**Attachment A – Detailed response to all submissions**

Green Square Integrated Facility and School – State Significant Development Application

6 ELEVATION - BUILDING NAME SIGNAGE  
1: 10

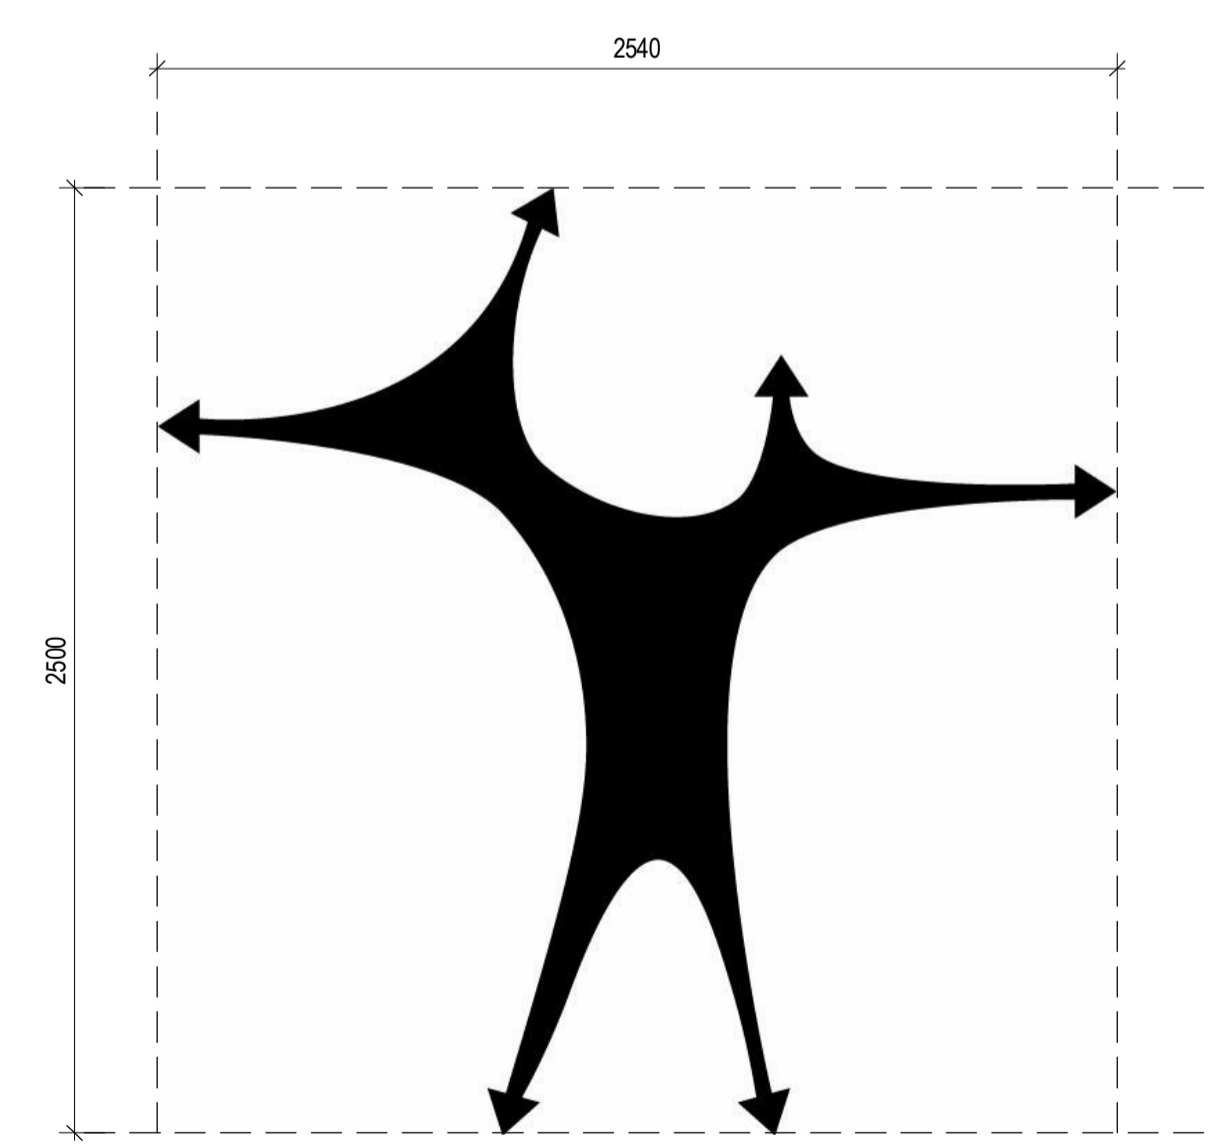
<p><u>Public Art</u></p> <p>13. <i>A Preliminary Public Art Plan is to be provided in accordance with the City of Sydney’s Guidelines for Public Art in Private Developments</i></p>	<p>13. A Preliminary Public Art Plan has been prepared by the Applicant (refer to <b>Attachment G</b>).</p>
<p><u>Signage</u></p> <p>14. <i>Signage details are to be included on the Architectural Plans including the floor plans and elevations and included in the visual amenity and view impact analysis.</i></p>	<p>14. Signage details have been updated on plans DA-B69-00-00, DA-B69-02-01, DA-B69-XX-01, DA-B69-XX-02 and DA-B69-XX-03 and included in the visual amenity and view impact analysis.</p>

Issue	Response
<p>15. <i>The proposed LED screen measuring 4000mm x 2000mm on the northern façade of the building is not supported in its current form given its size and associated visual impact. The sign should be amended to a smaller flush fitting, high quality material preferably non-LED editable sign appropriate to the proposal and its context.</i></p> <p><i>(Note: an amended assessment against SEPP 64 – Advertising and Signage is also required as it is considered that the assessment does not adequately assess the impact of the proposed sign)</i></p>	<p>15. The LED screen has been reduced in size by approximately 25%, from 2m x 4m to 1.5m x 3.5m (refer drawing DA-B69-XX-01). The operation of the LED screen will be limited from 6am to 10pm. This detail has been included in Section 14.3 of the updated Operational Plan at <b>Attachment E</b>.</p> <p>An amended assessment has been undertaken of the proposed signage against SEPP 64 (refer to <b>Attachment F</b>).</p>

DA-F63-XX-01

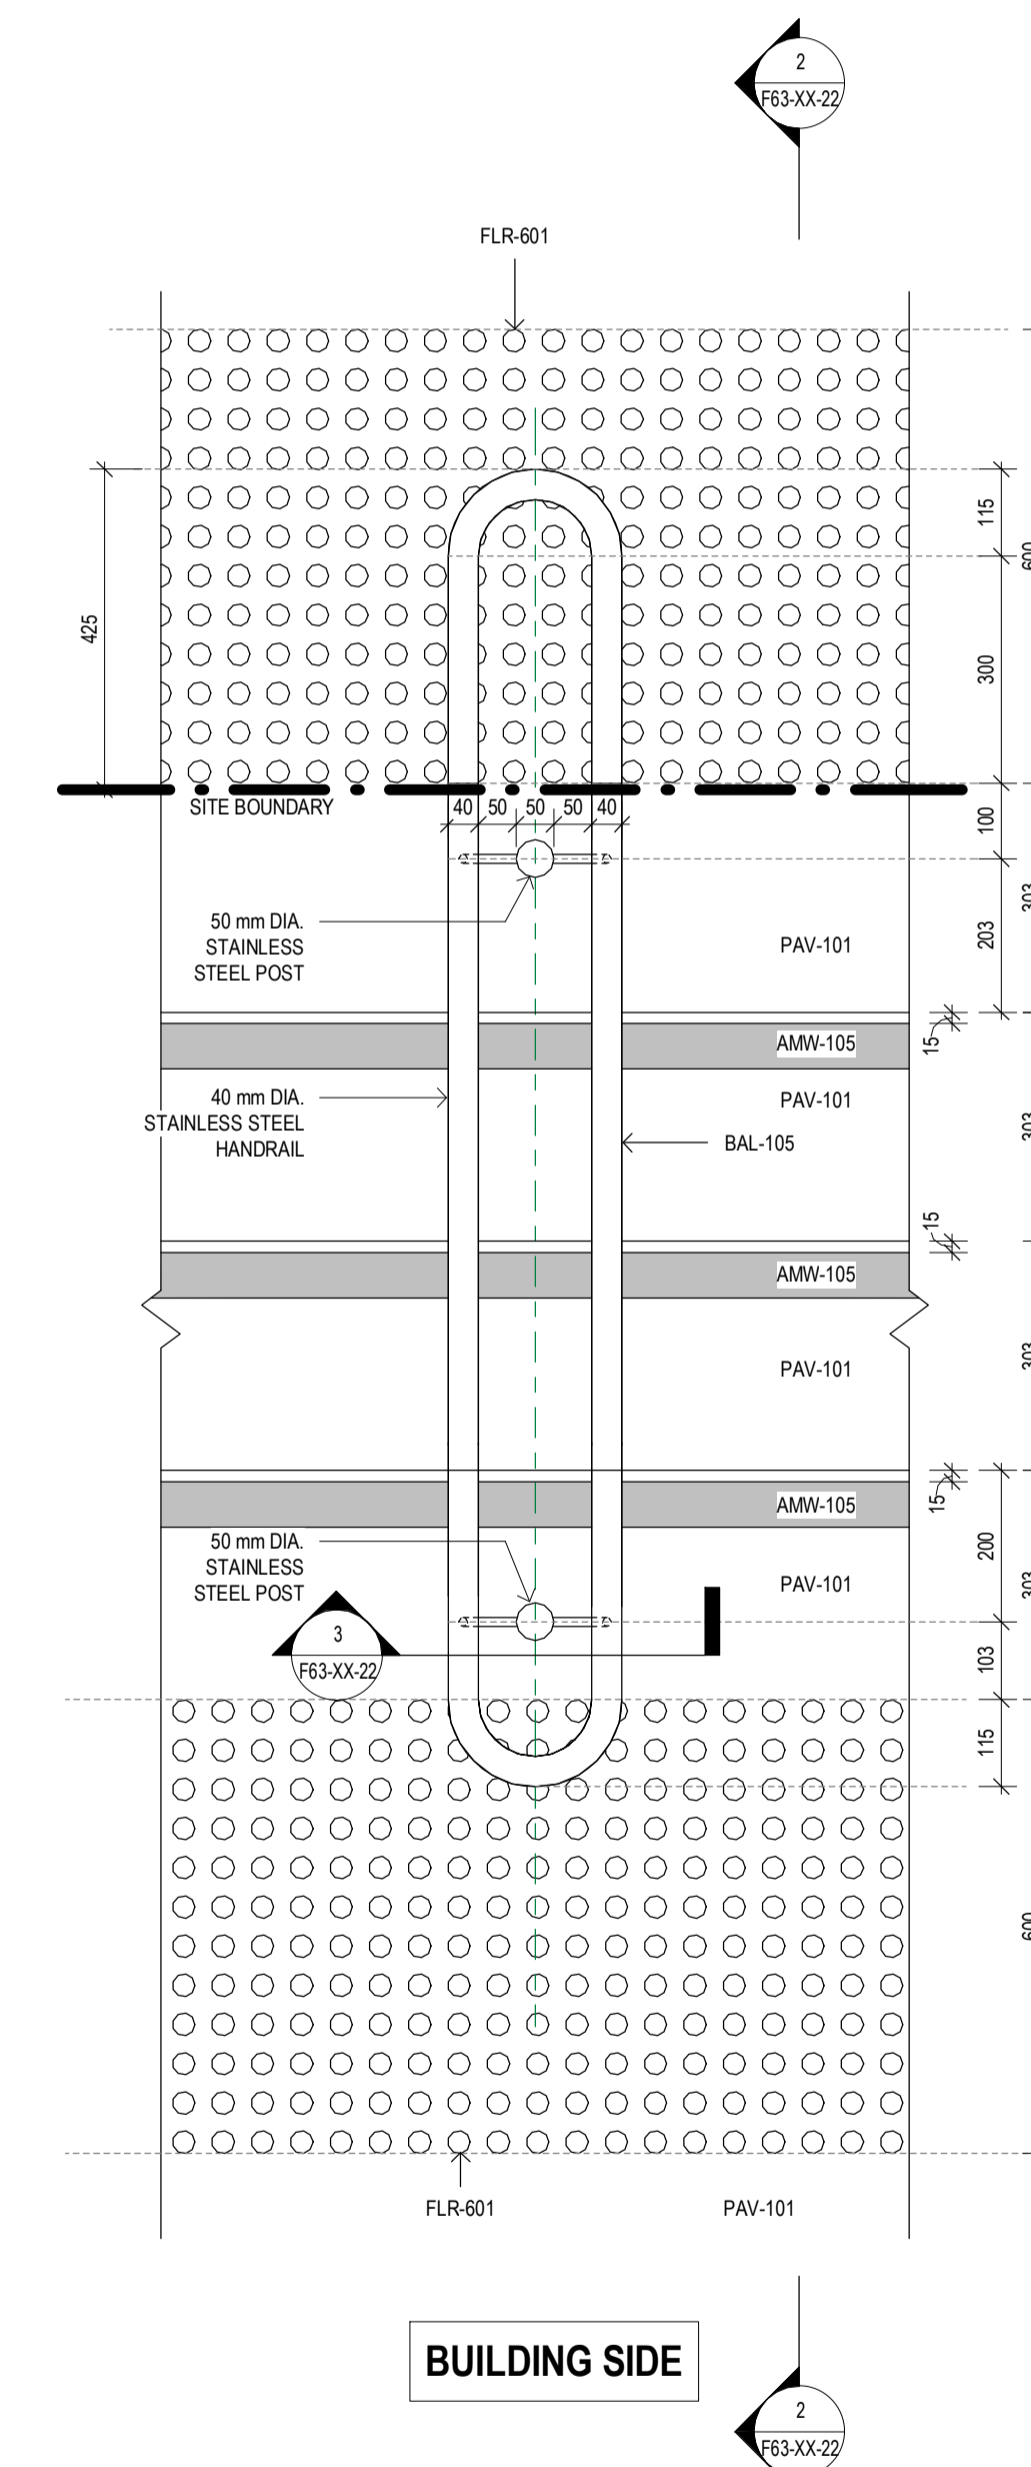
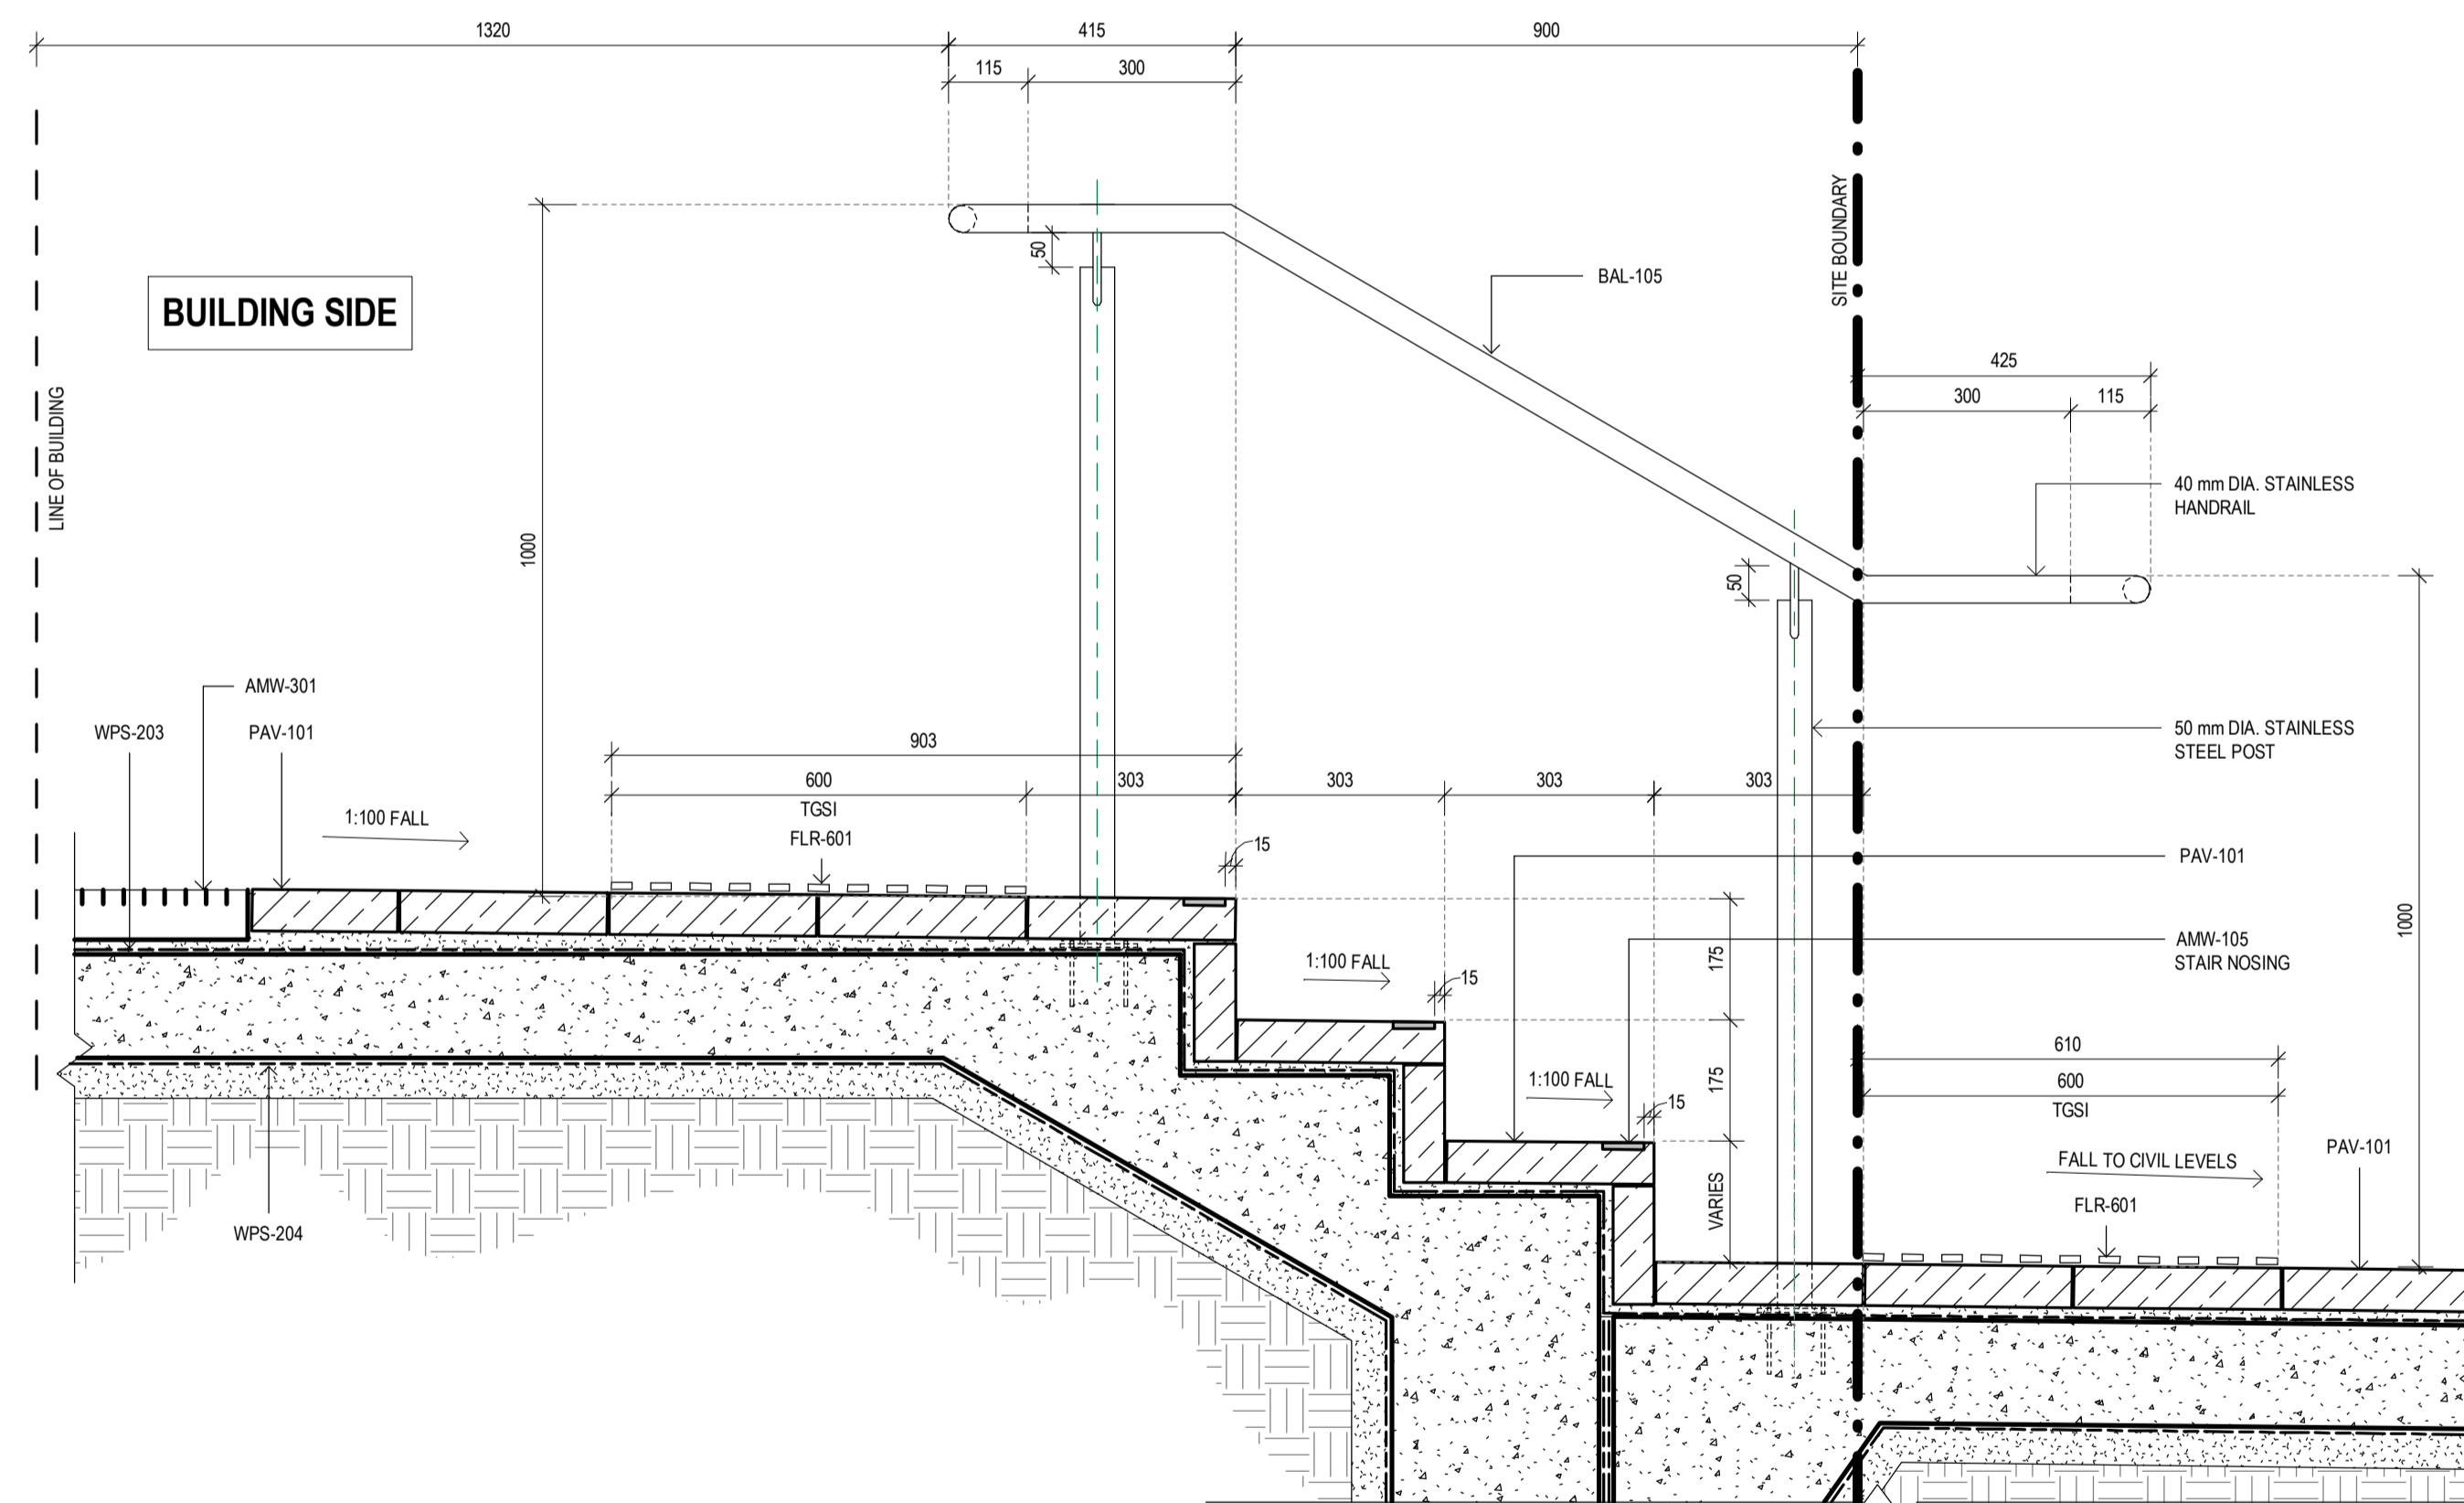
<p><u>Access</u></p> <p>12. <i>The recommendations of the Access report should be incorporated into the plans including:</i></p>	<p>12. The recommendations of the Access Report have been incorporated into the plan as follows:</p> <p>a. Plans updated to incorporate north ground tactiles. Refer to drawing number: DA-B10-00-00. For detail setout refer to drawing number DA-F63-XX-01.</p>
